The Coal
Authority

Re: 2024/62/92727/E

Erection of residential development 67 dwellings with associated access, parking, public open space, landscaping and infrastructure; LAND ADJACENT TO ASHBOURNE DRIVE, LIVERSEDGE - RECONSULTATION

DRAWN	DP	DATE	06 11 2024	STATUS	FOR COMMENT <input type="checkbox"/>
CHECKED	REG	DATE	13 11 2024	FOR APPROVAL	<input type="checkbox"/>
				DRAFT	<input type="checkbox"/>
				FINAL	<input checked="" type="checkbox"/>
SCALE	-	SHEET	A3	DRAWING NO.	1462/13
				REVISION

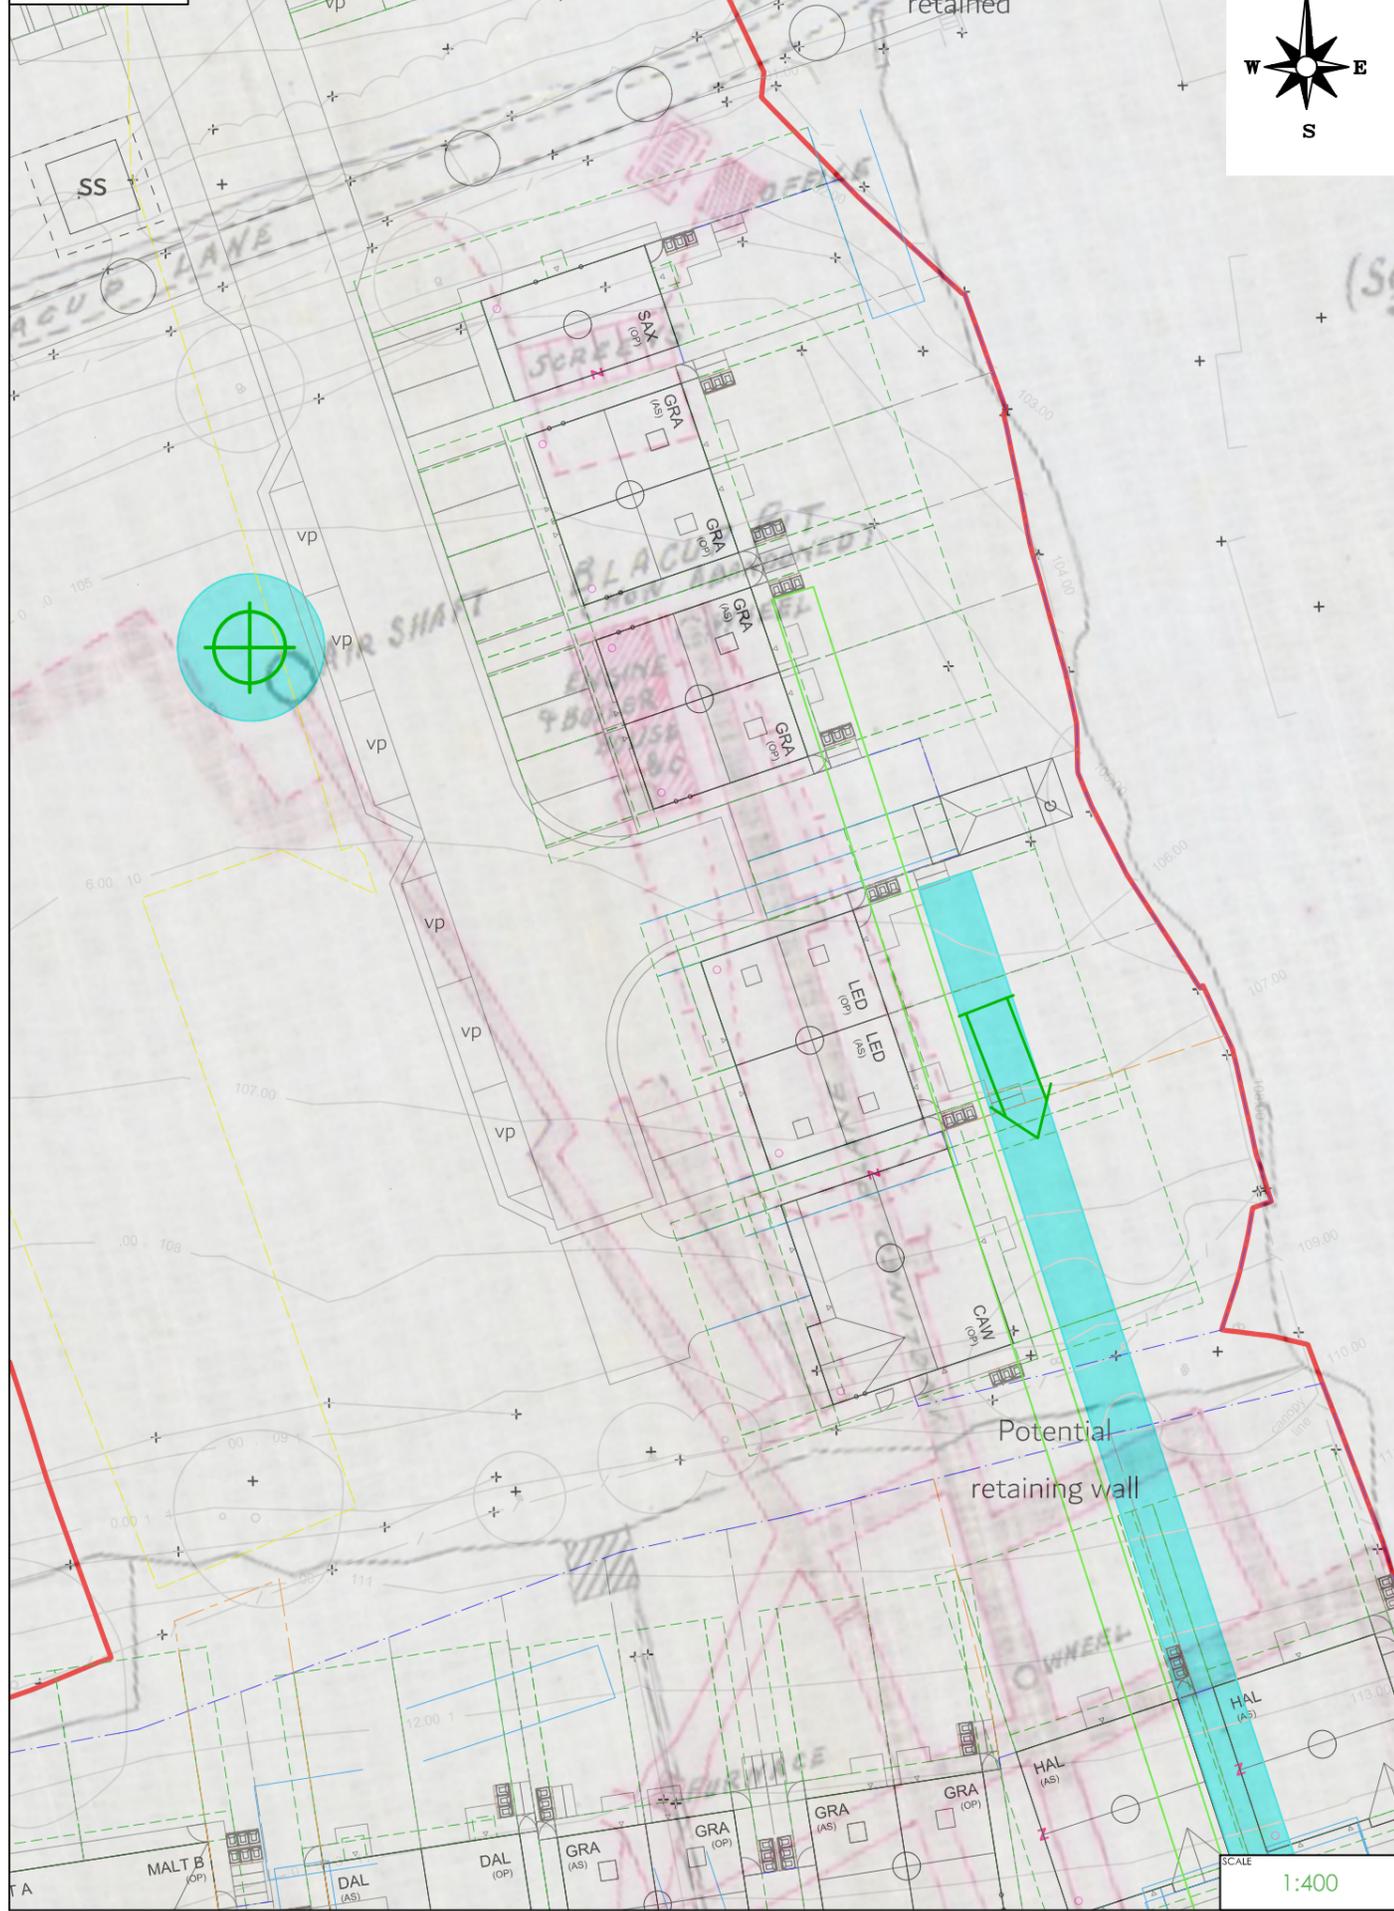
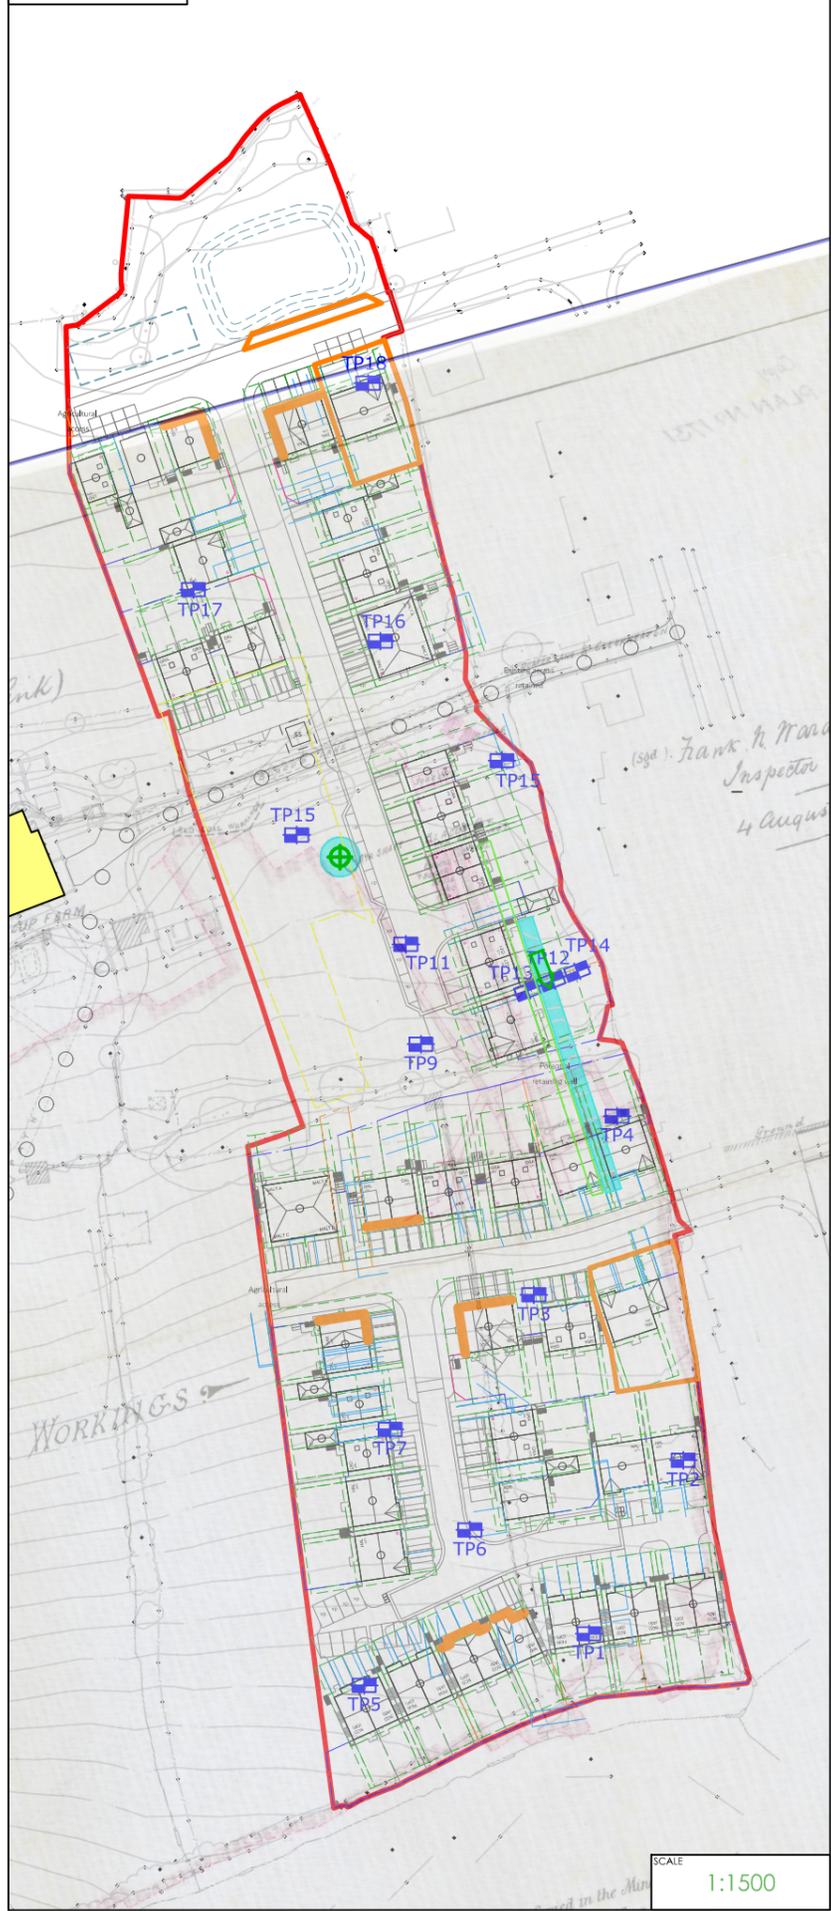
We welcome the submission of a letter Report (041/1462/REG dated 13th November 2022 prepared by Lithos Consulting. Lithos have now provided a plan to illustrate the surveyed positions of the mineshaft and mine adit (and roadway) and how this demonstrates that no

buildings are over or within influencing distance of these specific features (Drawing No. 1462/13. As the aim of the Report is to address the Coal Authority's concerns regarding the two mine entries in our letter dated 30 October 2024, we are assuming that the date quoted on the letter is incorrect and should be 2024.

In light of the above, as no built development is taking place over or within influencing distance of the on-site recorded mine entries; the Coal Authority has no objections to the proposed development subject to no changes being made to the layout as per Drawing No. 1462/13.
